Redevelopment of Parramatta Public and Arthur Phillip High Schools at 80-100 and 175 Macquarie Street, Parramatta.

The City of Parramatta Council would like to raise the following concerns with the information currently provided as part of the application.

Parramatta Public School Detail Plan

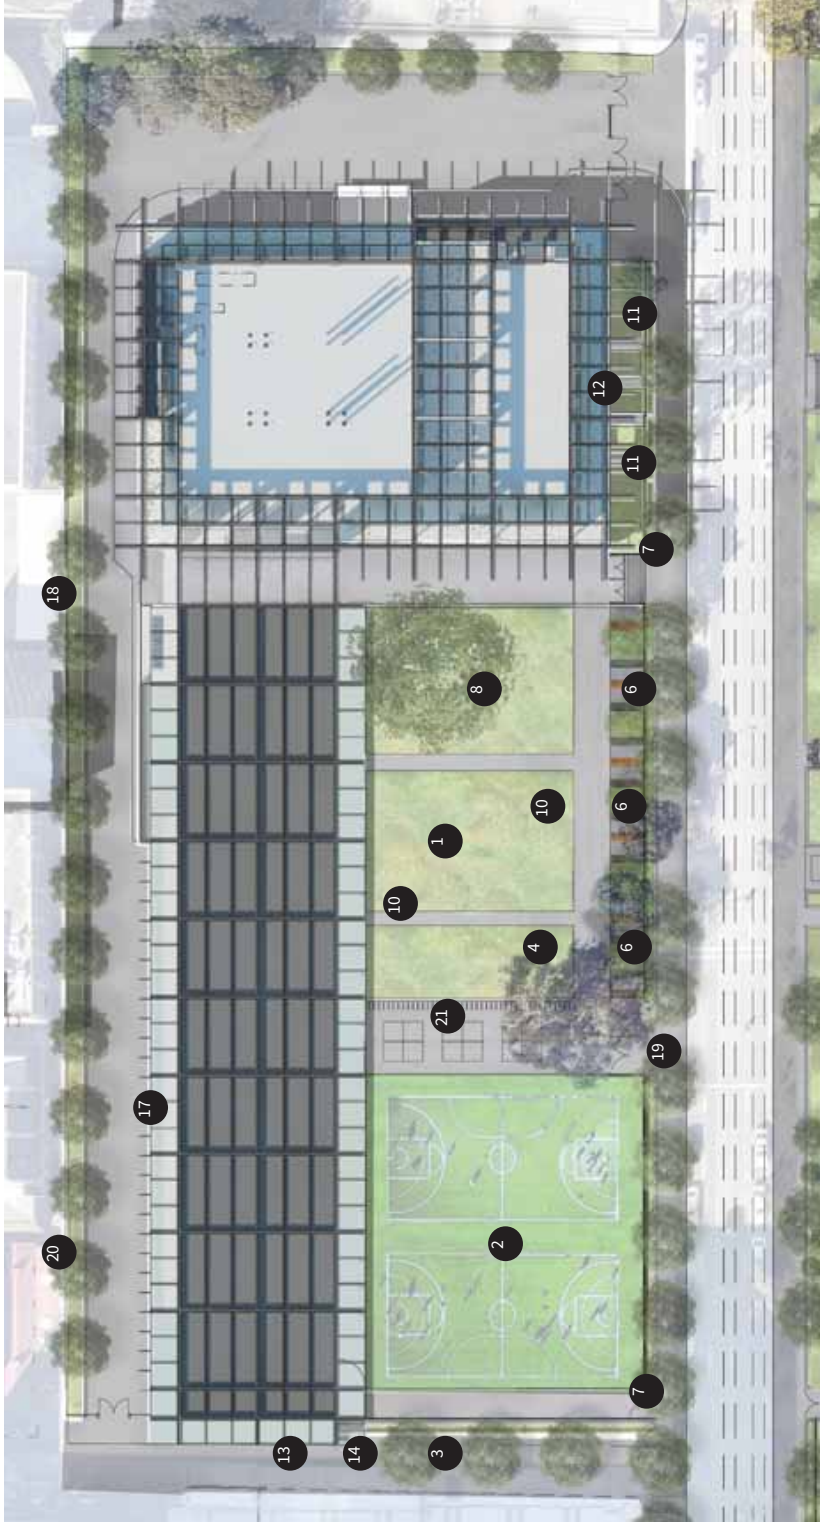
1. The changes to traffic conditions in Little Street including the pedestrian refuge island discussed below are to be funded by the applicant.
2. The proposal includes changes to the angle parking in Little Street to create an additional 8 parking spaces.

3. The traffic study by the applicant does not include traffic and pedestrian counts for the intersection of Charles Street and Little Street.
4. The proposal includes a left in/left out arrangement in Little Street at Charles Street. This could be implemented by the installation of a pedestrian refuge island, however, this would require a fence to discourage pedestrian using it (it is preferred that pedestrians use the signalised crossing to the north and south of Little Street). An island would also require the restriction to be full time whereas a part time restriction could be imposed if the restriction is only signposted. Furthermore, a fence would stop Police making the right turns for emergency access.

6. There is currently no pedestrian facility to cross Little Street at Charles Street. There is not enough information provided with the application to know if a pedestrian crossing would meet the pedestrian and traffic volume requirements set by RMS. A pedestrian refuge island should be installed as part of the development. It should be designed so that Council can install a pedestrian crossing at the refuge island in future if the RMS requirements are met.

5. A left in / left out restriction is to be provided at the intersection of Little Street and Charles Street and is to be implemented via signposting only. This shall be funded by the applicant at no cost to Council.

7. A pedestrian refuge island shall be provided to facilitate crossing of Little Street at Charles Street. This island shall be designed to accommodate the requirements for the installation of a pedestrian crossing, in accordance with AS1742.10-2009 and RMS Australian Standard Supplements AS1742 Parts 1 – 15; pending assessment of pedestrian and traffic volumes in terms of RMS requirements. This shall be funded by the applicant at no cost to Council.

Fence and Boundary Conditions

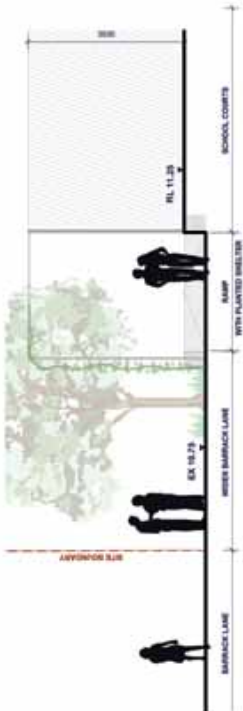
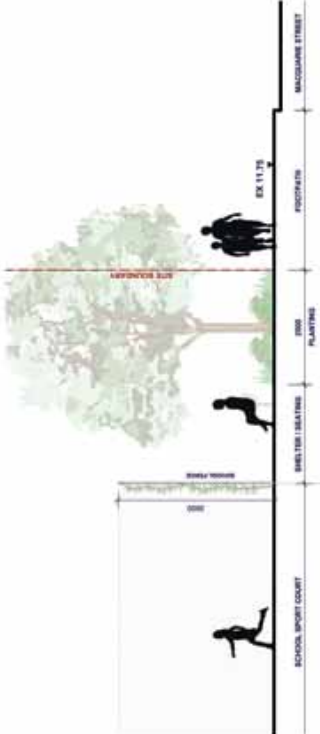
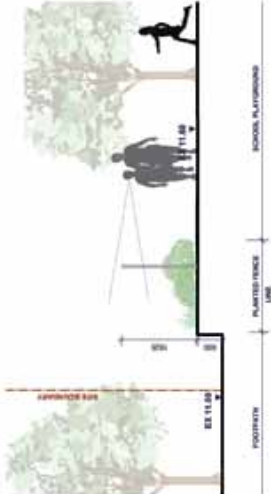
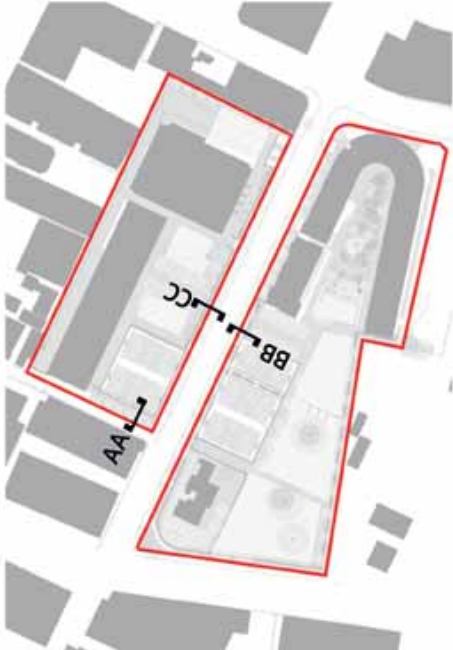
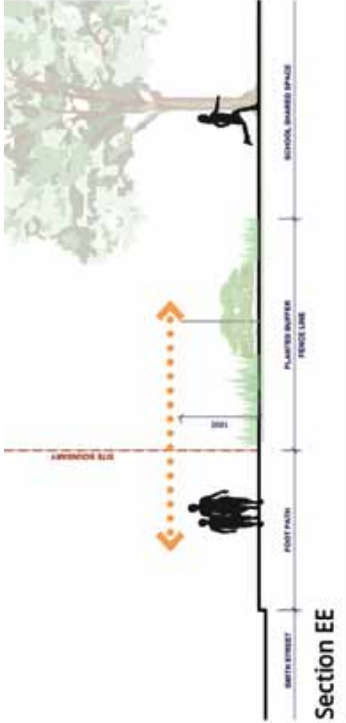
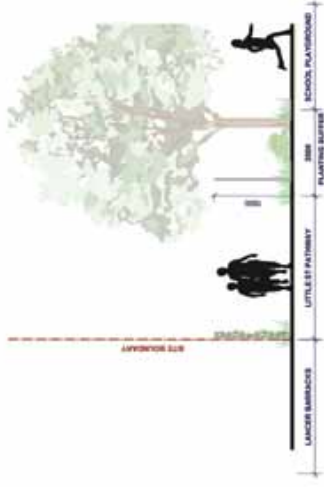
Further details are required especially in relation to connections with the public domain and fencing. It would be appreciated if the applicants could present to Council so that a greater understanding of the connections can be achieved.

Fencing

Insufficient detail is shown in relation to the proposed fencing. The fencing chosen will have a large impact on the relationship between the public domain and the school and requires further discussion with Council before it is agreed.
